Re: Fireflower
214 San Pedro Dr. NE
Traffic Circulation Layout
Engineer's Stamp 08-19-22 (K18-D112)

Based upon the information provided in your submittal received 09-07-22, the above referenced plan cannot be approved for Building Permit until the following comments are addressed:

File Name: P:\data\2022\027 3\ENG\220273 DstBaseR1.dwg - CP1.1-R1 Plot Date: 10/11/22 Plot Time: 14:49

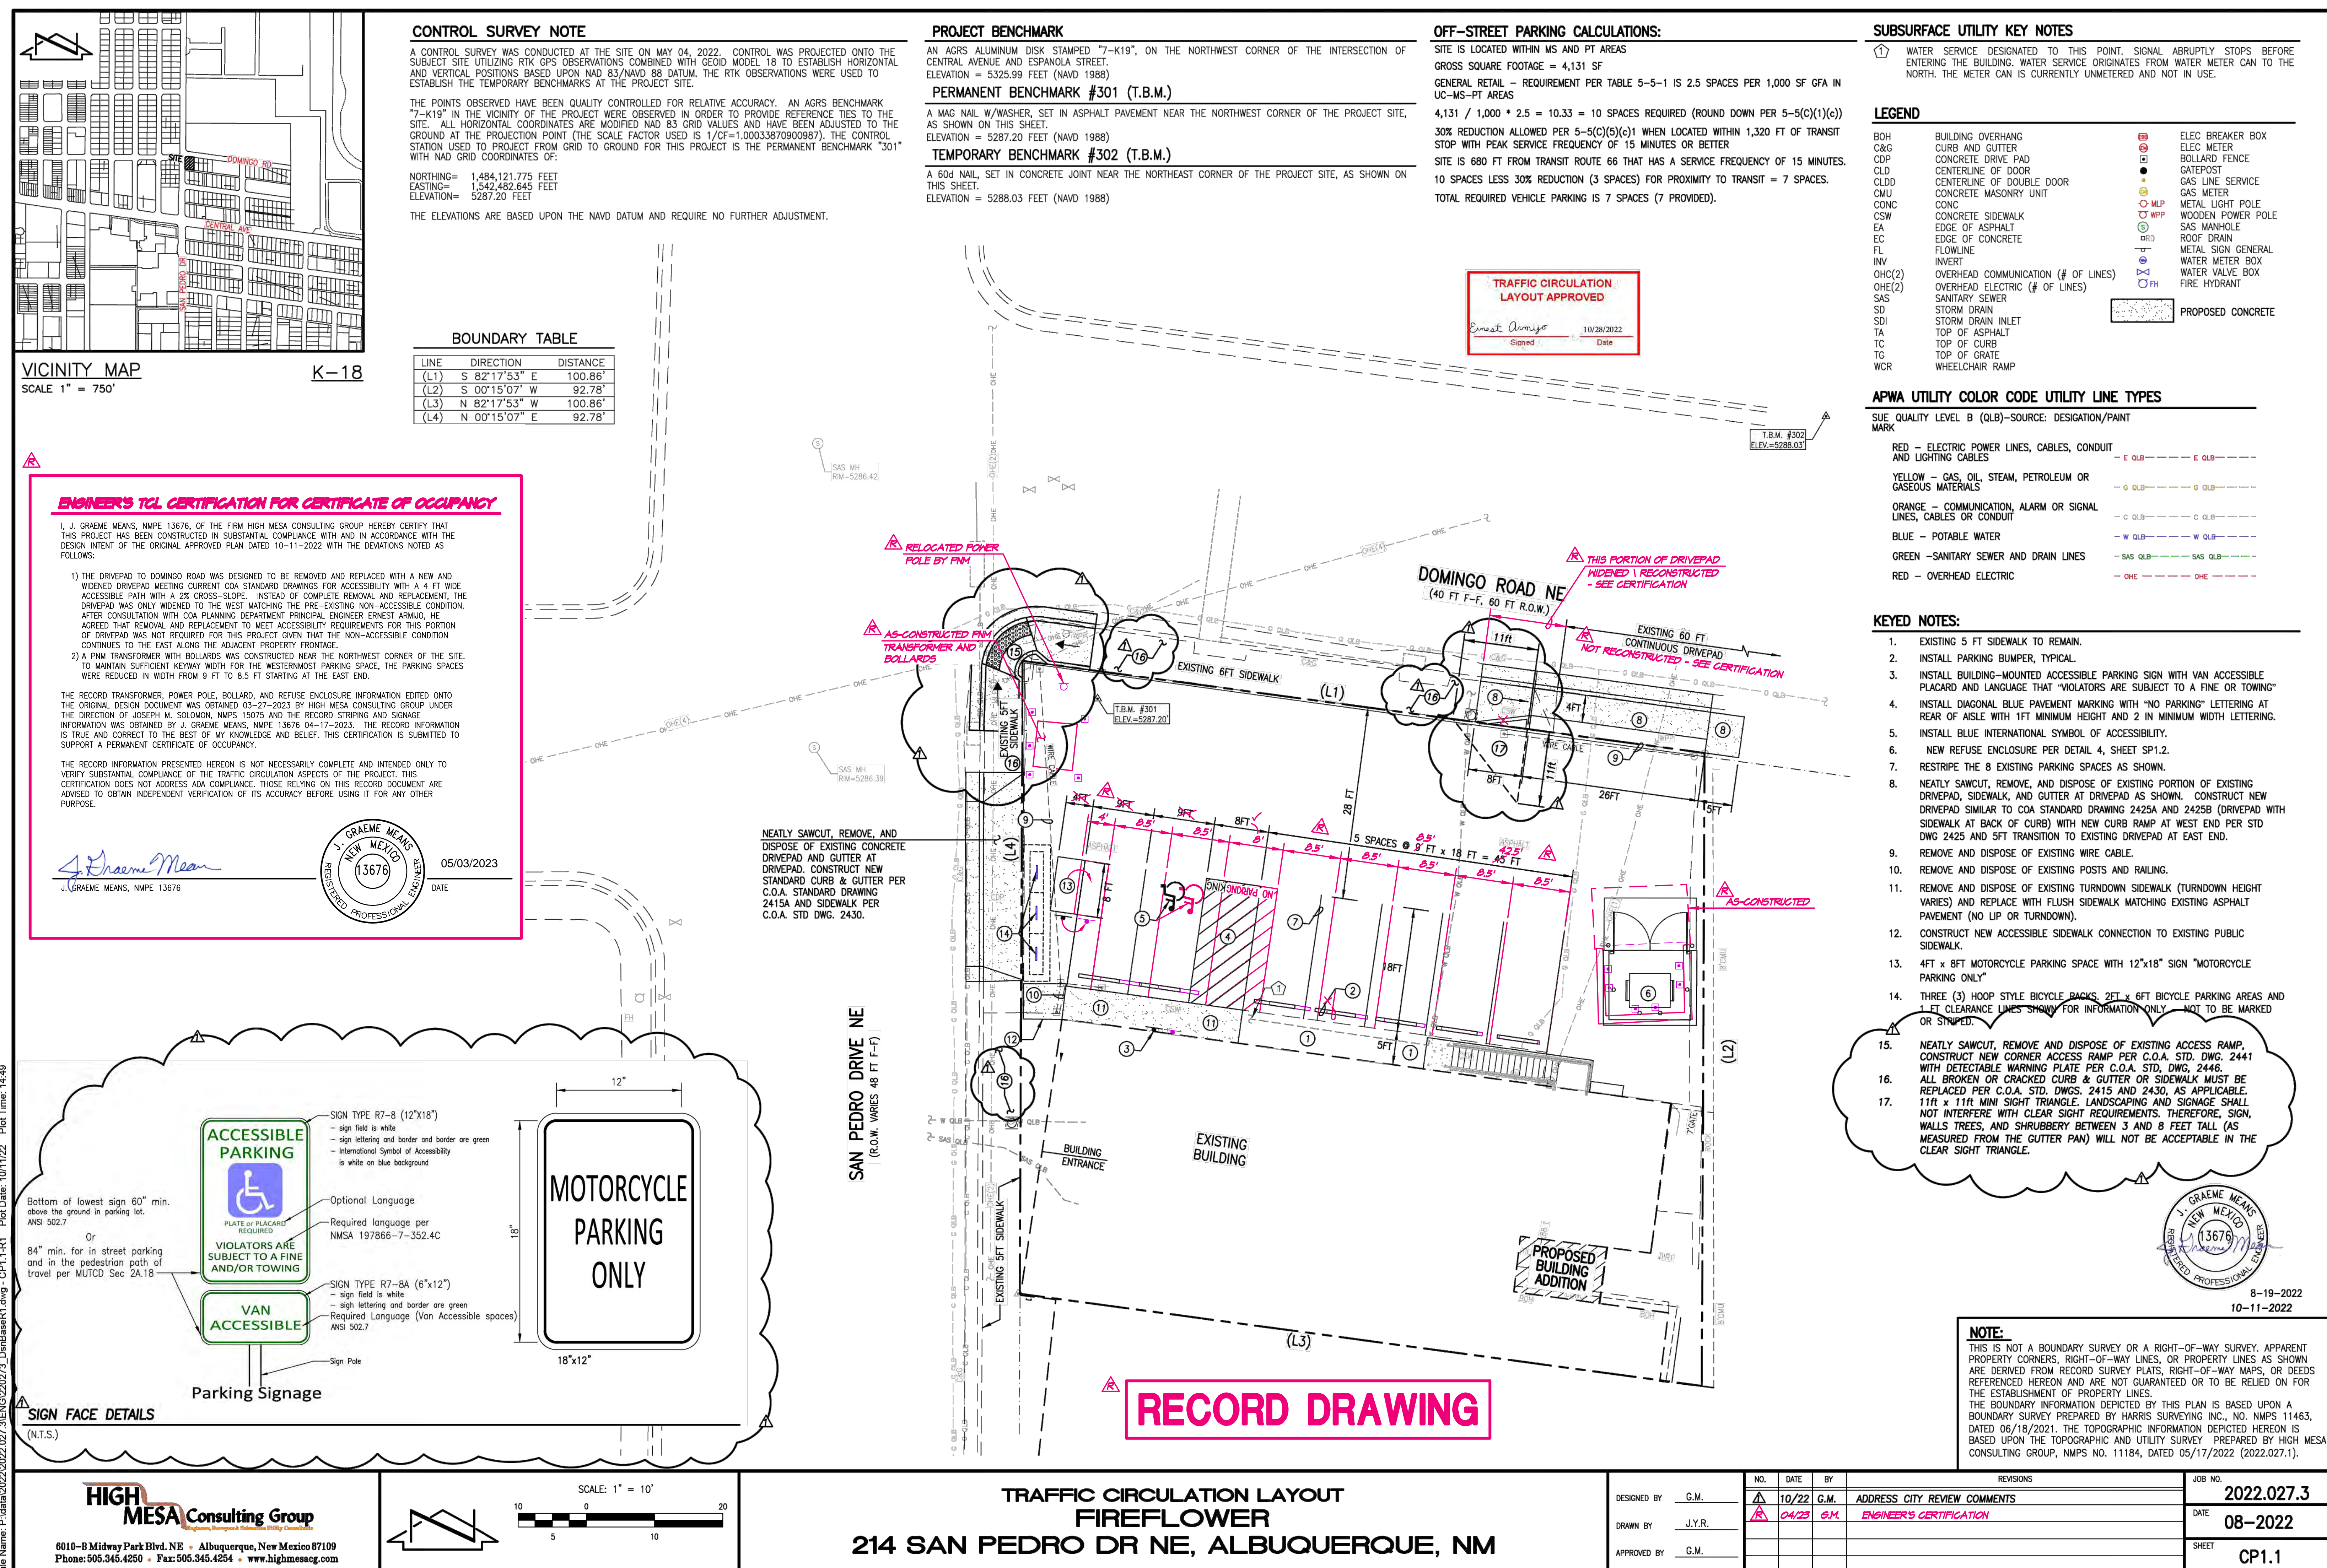
1. ADA curb ramp at the corner of San Pedro and Domingo Rd. must be updated to current ADA standards and have truncated domes installed.
2. Provide face sign details for all the proposed signs.
3. Provide a copy of Fire Marshal approval.
4. Please provide a sight distance exhibit
5. Show the clear sight triangle and add the following note to the plan: "Landscaping and signage will not interfere with clear sight requirements. Therefore, signs, walls, trees, and shrubbery between 3 and 8 feet tall (as measured from the gutter pan) will not be acceptable in the clear sight triangle.
6. Add a note stating "All broken or cracked sidewalk must be replaced with sidewalk and curb & gutter." A build note must be provided referring to the appropriate City Standard drawing.
7. Please provide a letter of response for all comments given.
